TEXT_M25J28_ISH3_Session2_12052021

Good morning and welcome back. We will now recommence this issue specific hearing on M 25. junction 28 improvement scheme. Before we carry on, can I remind any live streamers that they will need to refresh their browsers in order to view

Now, we will move on to the next item of the agenda, which is the adequacy of the outline traffic management plan.

Drawing Title: **TEMPORARY TRAFFIC MANAGEMENT
A12 EASTBOUND ON SLIP ROAD CLOSURE
DIVERSION ROUTE**

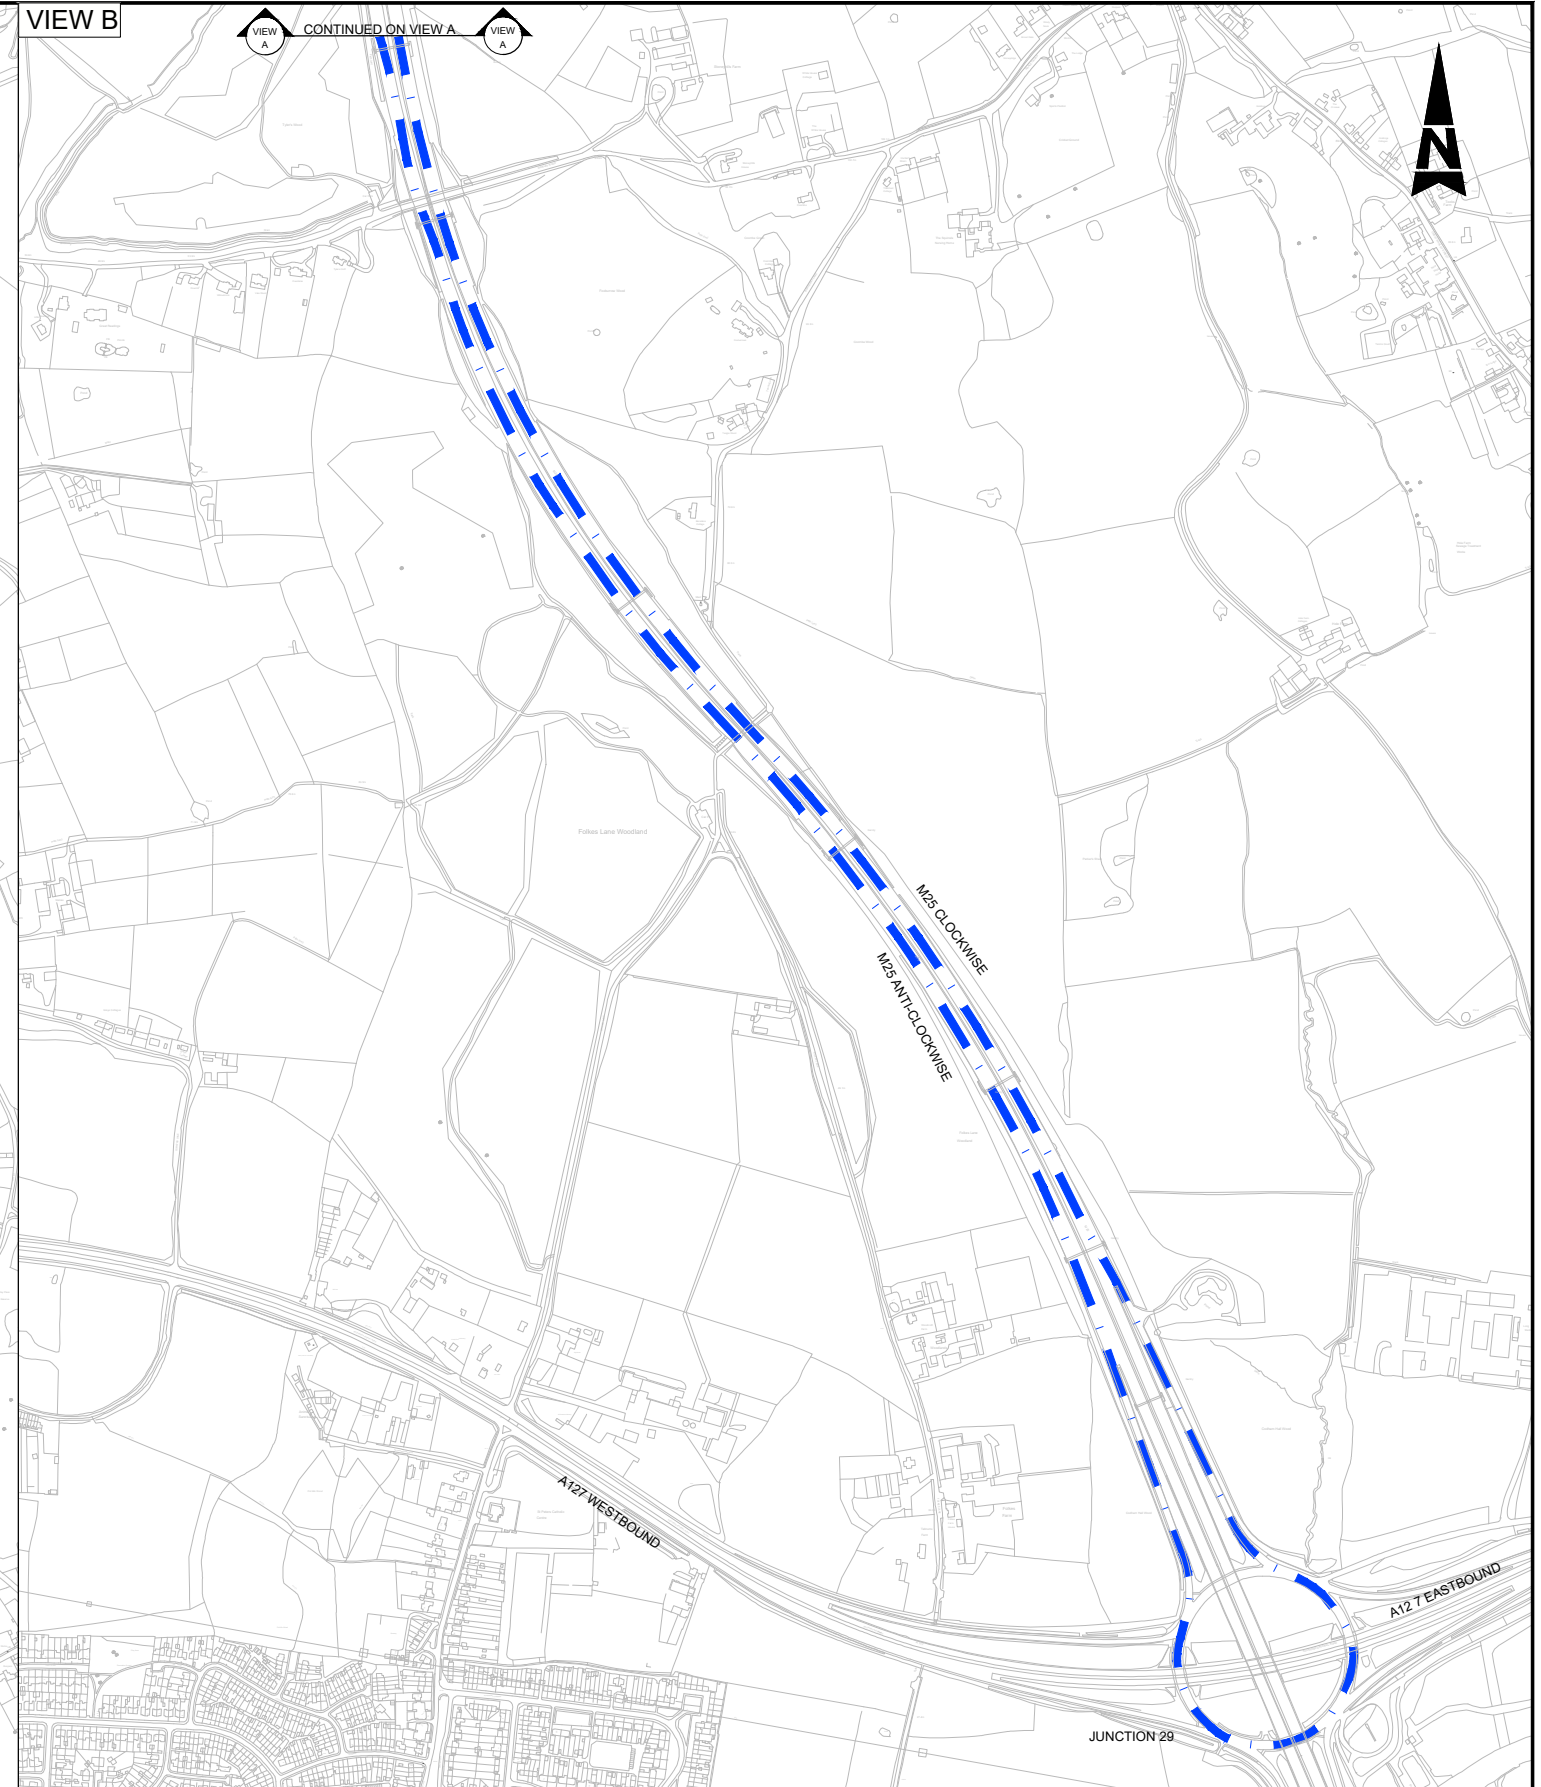
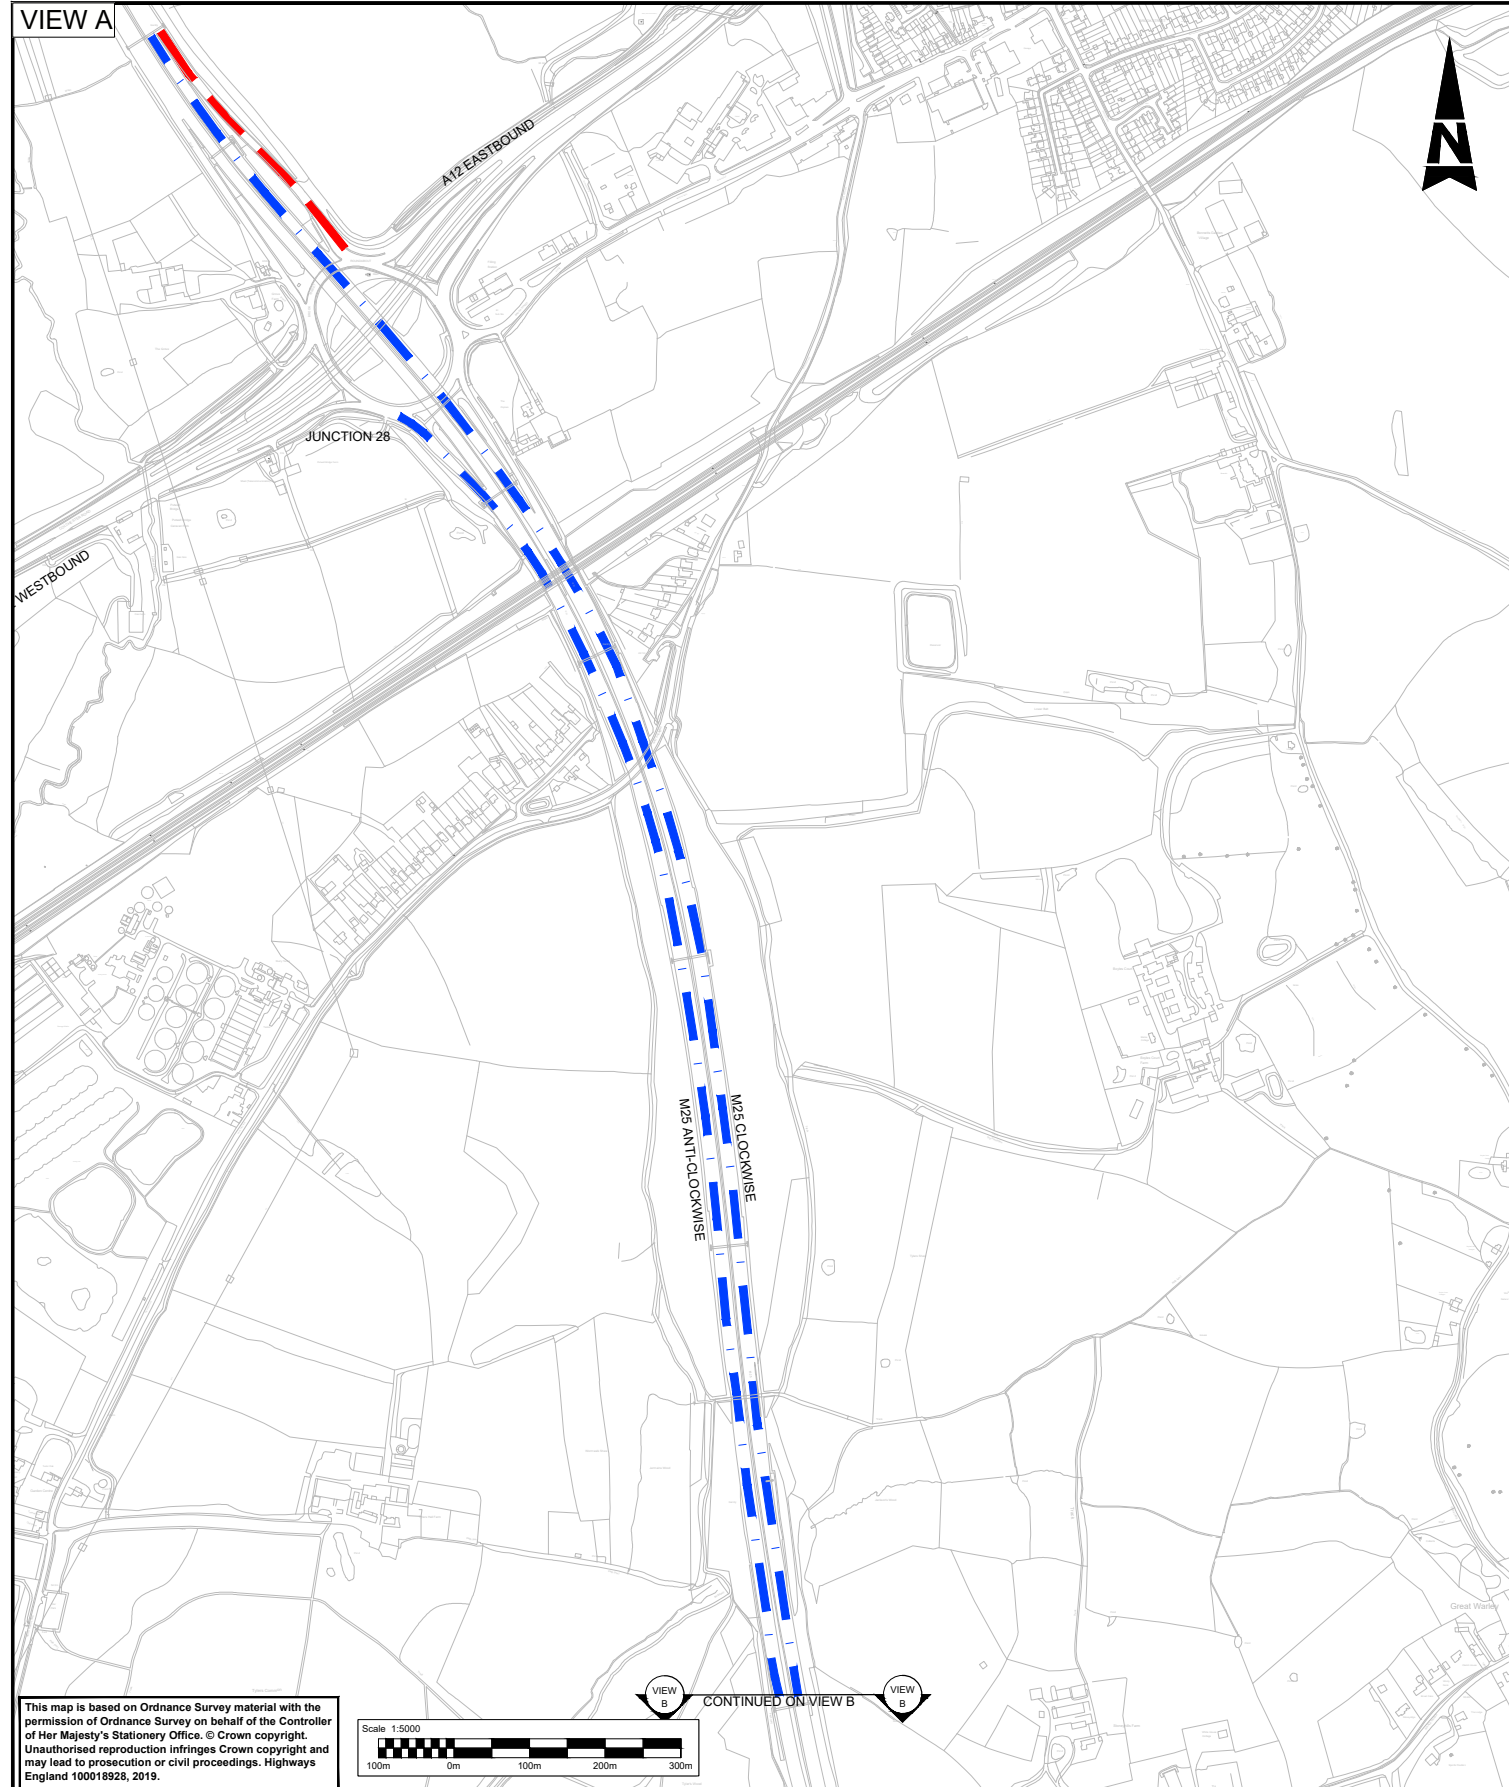
when responding to the panel's second set of written questions. We we raised the point hiring raised the point that the the the temporary closure of the a 12 is bound off slip didn't appear to have been included within the outline traffic management plan. We certainly feel it should be

Be prepared to approve the final version if you're satisfied that this is the case. So, for us there appears to be a bit of a discrepancy about whether or not the outline traffic management plan is going to include the temporary closures of the A to A 12. eastbound off slip and we'd invite the panel to to to request clarification from the applicant as to whether

Yeah, I can outline the areas that we're currently updating the outline traffic management plan. So we are going to be including information on the overnight closure, particularly the a 12 eastbound off slip, which as we've said before, we believe a very short term, overnight closures are unavoidable and to construct the works for the the scheme. So that will be included in the end a plan that shows the proposed diversion, which we recognise is quite lengthy, but it has to be borne in mind that that diversion would only be in place at night. When there is very little traffic on the roads. It would be outside the pay periods and therefore the

diversion route we've looked at the off peak journey time for driving from Woodstock Avenue up to the next junction east on the to the east on the a 12 and then back down again. And we think it adds between 12 and 15 minutes to the journey time. But the actual journey time is actually not much longer than it is during the peak hours currently because of the levels of congestion you get at the junction. So even though it involves quite a considerable extra distance, we don't think the journey time because it is an off peak period when traffic flows are free flowing, the actual journey time difference between make trying to make that journey say it during the busy time the day is not significantly different.

Drawing Title: **PETERSFIELD AVENUE
CONSTRUCTION TRAFFIC U-TURN
SWEPT PATH ANALYSIS
ARTICULATED VEHICLE**

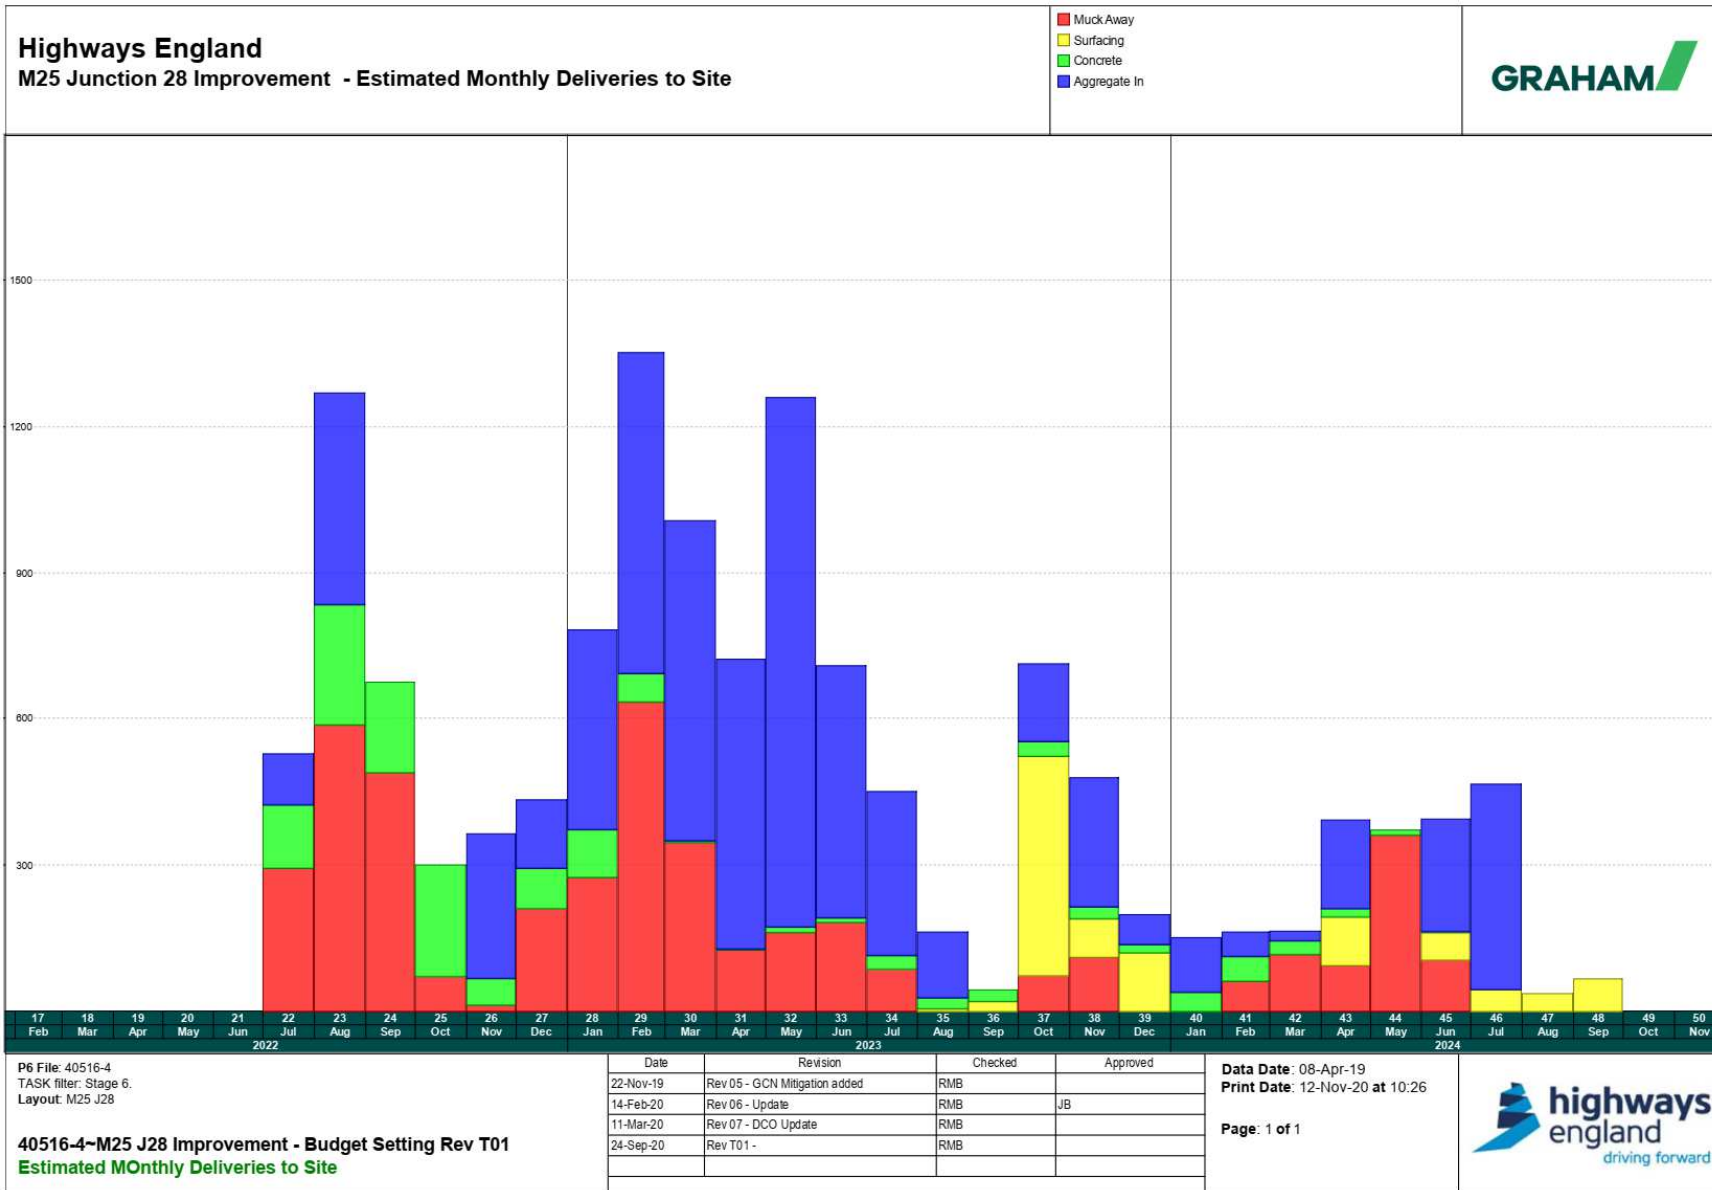
sorry, paragraph 2.3. point five of the outline traffic management plan, which refers to the the sweat path analysis that's been carried out

in relation to the U turn at Pittsfield Avenue junction.

acknowledged that piece of road Avenue is not wide enough to allow it to articulated hdb's to make a U turn at the junction and that

instead, these vehicles would need to use you need to use gallows corner in order to access the the site compound.

I think from from havens perspective, when we just reiterate the concerns that were raised at the at issue specific hearing one in relation to the impact of construction traffic on gallows corner, if there's going to be an additional 95 movements

exiting, and some of these use using gallows corner junction. The concern is the impact that might have on that junction itself. So we just like to reiterate our concerns on that. And we would we'd also suggest that

HDB lorry movements should be restricted to outside the the the morning and afternoon peak periods. Thank you.

Pittsfield Avenue and the intention is that all traffic construction traffic will therefore be directed to U turn at gallows corner. Because the it's too complicated to send traffic to different routes depending on the size of vehicle and it would only end up confusing suppliers and subcontractors. So, it is preferable to have a single defined route. And in the outline traffic management plan we have now made reference to the fact that there will be

the swept path analysis and the indication of a U turn up Petersfield Avenue is are you saying that that's that's no redundant there there is no intention for there to be any U turn manoeuvres Petersfield Avenue within within the traffic management plan. That's correct. Okay, so that will effectively that will be removed. Yes. Thank you.

Yes, everything will be directed to you turn a gallows corner. And in terms of the point about the impact of the traffic on gallows corner, we do not believe the volumes of traffic involved will have a material impact on the operation of gallows corner.

That's per day, we think that adequate will equate to roughly one vehicle every 10 to 12 minutes

using gallows corner to to to access the site and we don't believe that that is sufficient additional demand given the background flows of gallows corners to have any material impact on the operation.
